**CITY OF ALBUQUERQUE
PLANNING DEPARTMENT
March 27, 2013
DRB Comments**

ITEM # 15

PROJECT # 1009506

RE: Tracts 14-18, 20 & 21, Volcano Cliffs Unit 6

SKETCH PLAT FOR
MONTECITO WEST PHASE 2

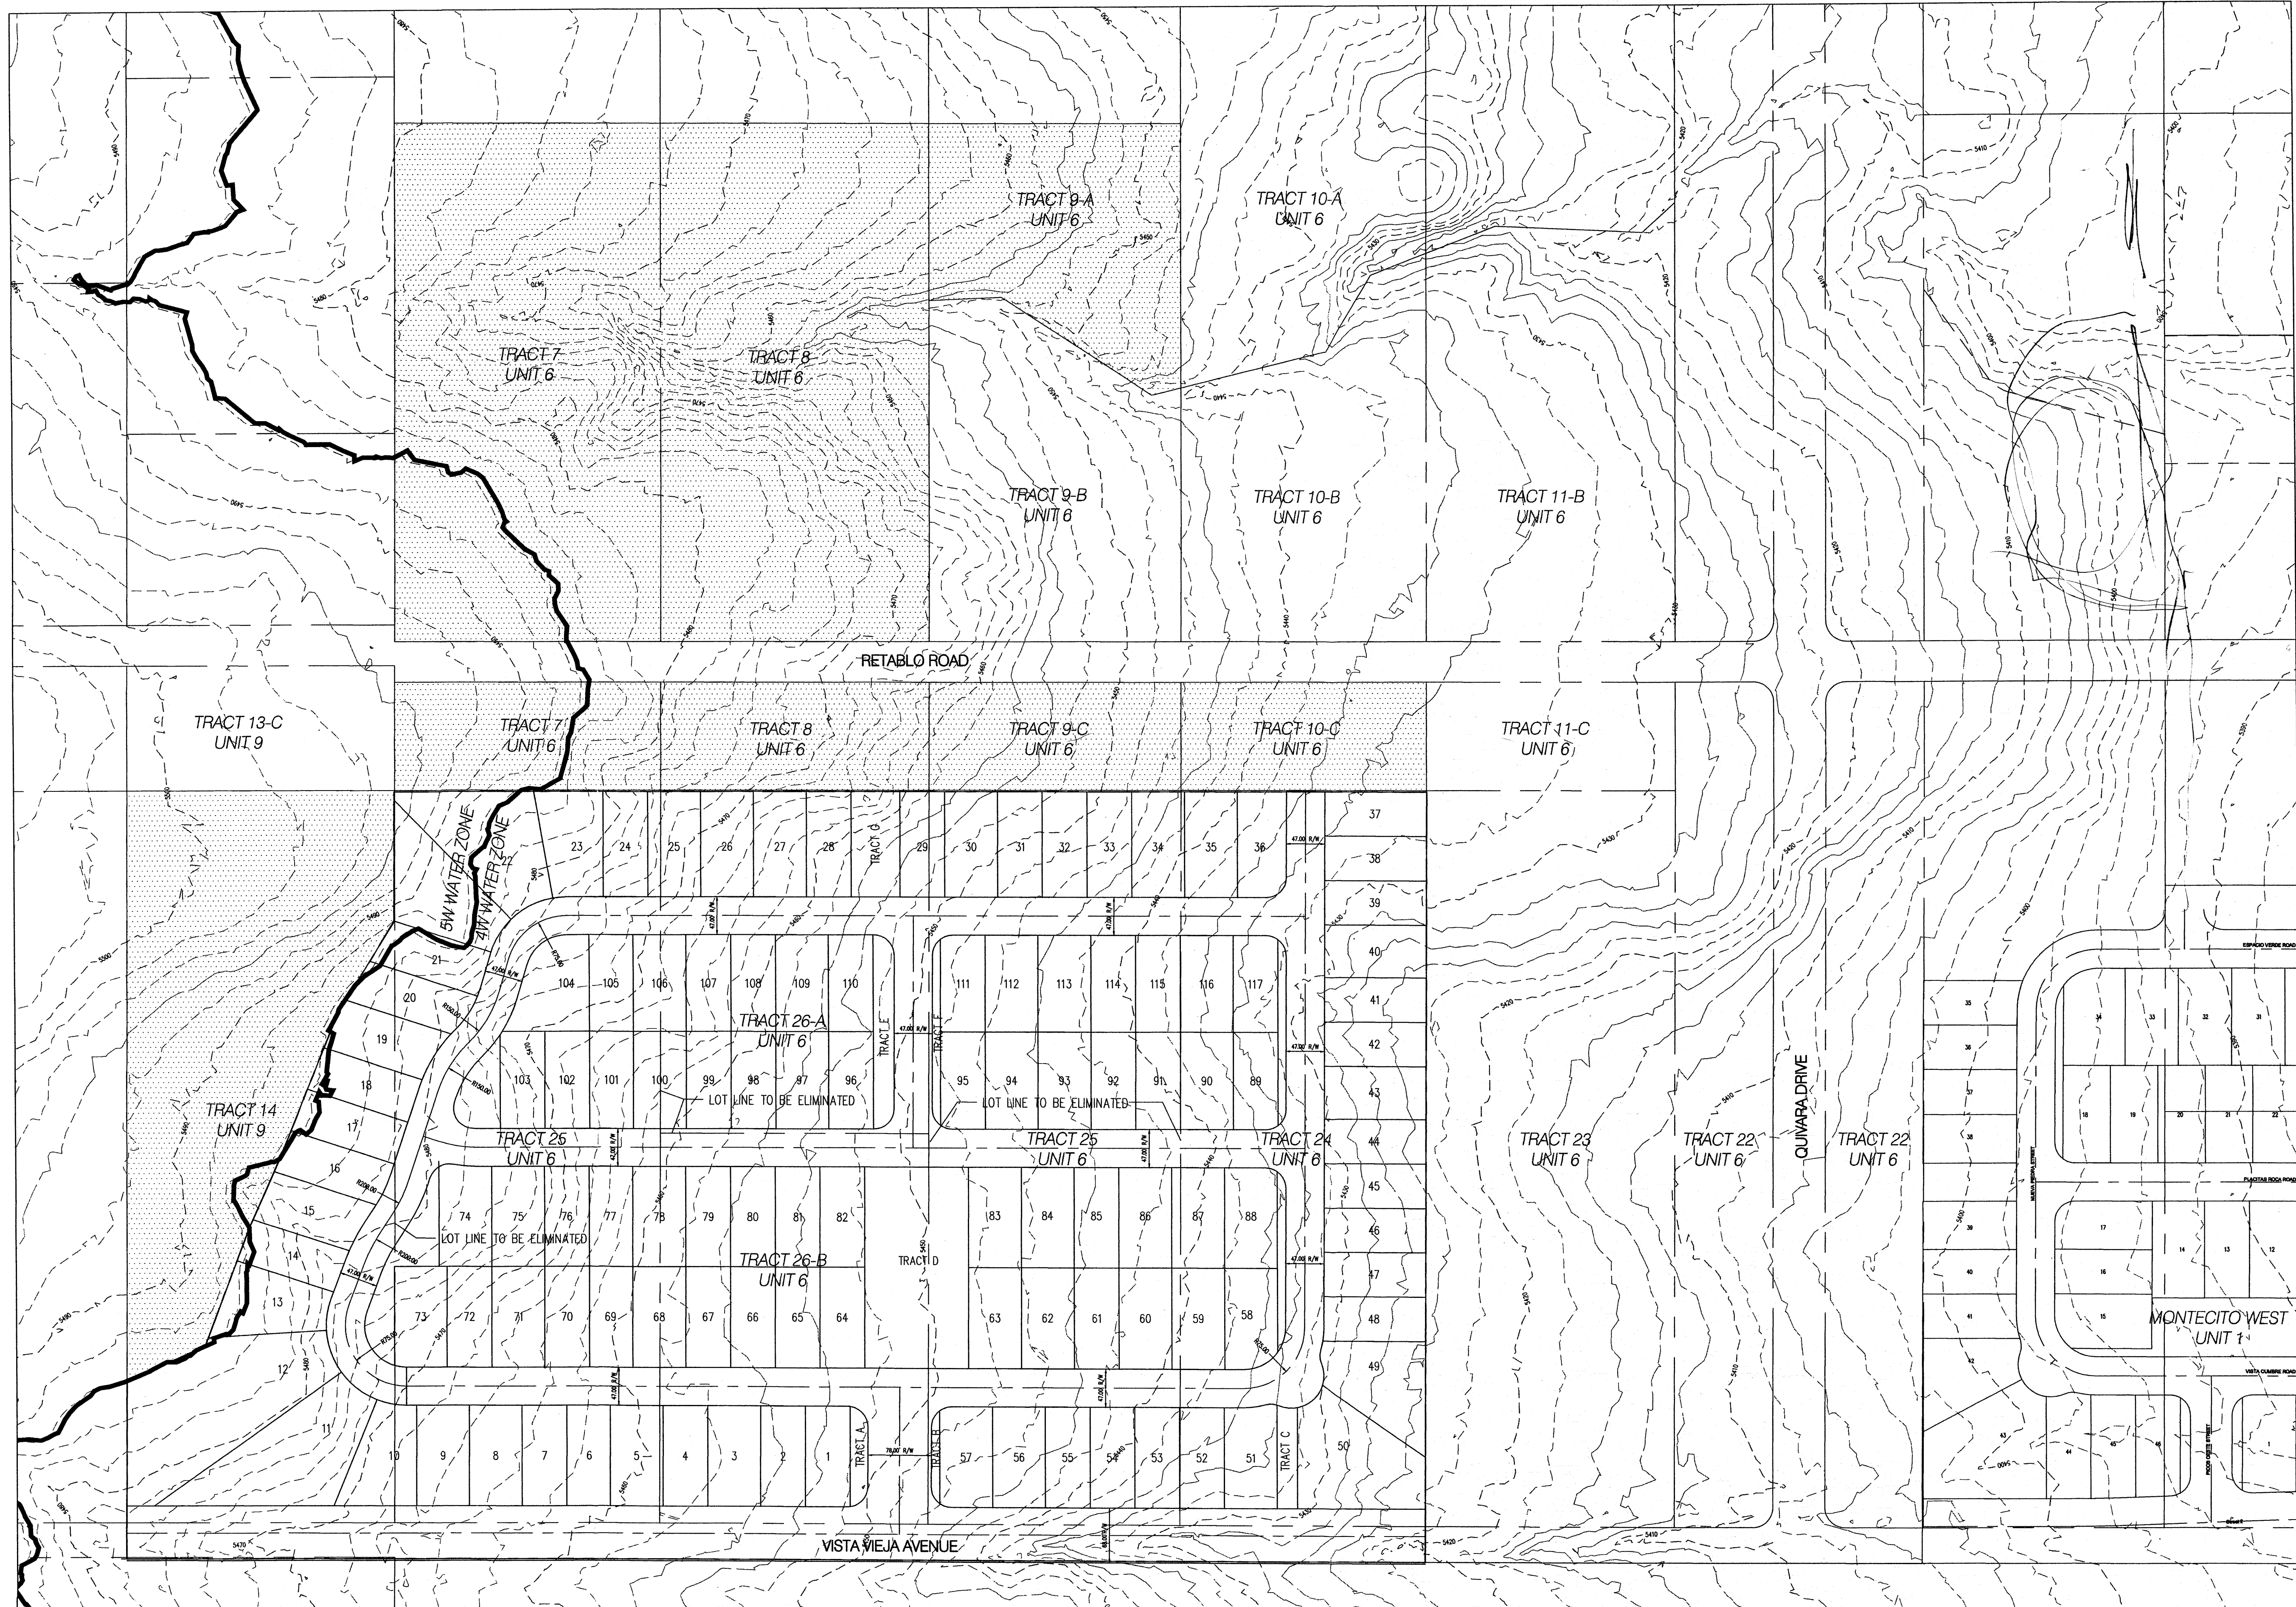
Refer to Section 14-16-3-16 of the Zoning Code for requirements of a Private Commons Development. Proposed subdivision would require the participation of Tract 1 on the north side.

Alternative lot layouts need to be explored – it is not suitable to create so many single loaded streets, and double frontage lots are extremely inefficient. Connectivity needs to be provided within the subdivision and from east to west – this would include tract 19.
